Re: Cairn Planning Application -Barrington Tower at Brennanstown Road

ABF Ref. 313281

Observation on Strategic Housing Application by Cairn Homes Properties Limited: Demolition of 'Winterbrook', and the former dwelling attached to Barrington Tower, construction of 534 no. Build to Rent apartments, creche and associated site works. Address of development: "Barrington Tower", Brennanstown Road, Dublin 18. (ABP Ref. 313281)

Proposed Site plan showing surface parking

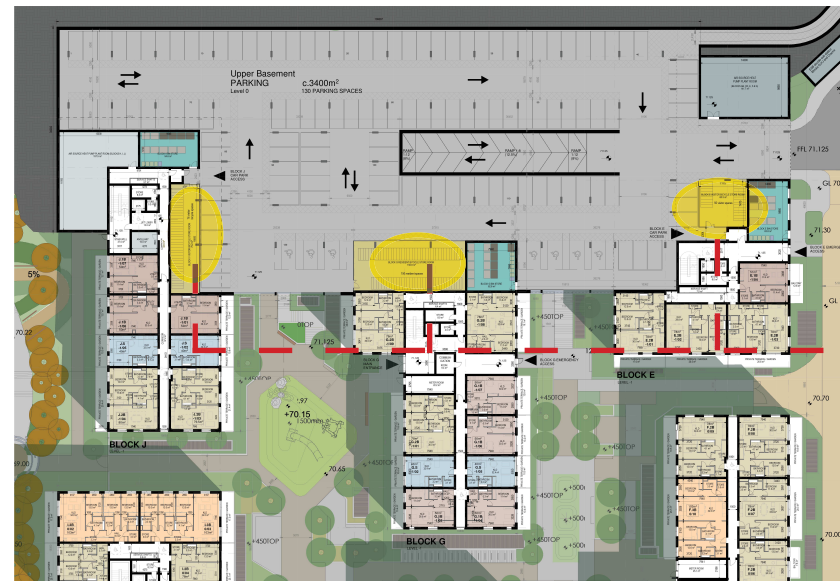
5. The Site Layout as proposed does not appear to be compliant with TGD B Fire (2006) Section 5.2 Vehicle Access.

The smaller five storey front blocks' top floor is more than 10M above GL and their volume exceeds 7,000 cubic metres. These and all the bigger blocks require a 5M wide hard standing to give access to 50% of their perimeters, a 3.7M wide access road and turning facilities. Attempting to comply with these requirements will significantly reduce the proposed public open space and it is not clear how 50% of perimeter access will be provided.

The clustering of the remaining six blocks should be reconsidered. Their height and close proximity lead to overlooking, loss of privacy and visual obstruction towards the western boundary, creating a shadowed, low-amenity windswept environment between the blocks. Providing proper fire tender access will significantly reduce the depth and quality of the proposed public open space to the west of the site. This suggests that at least two more blocks should be deleted from the lower part of the site for any new proposal.
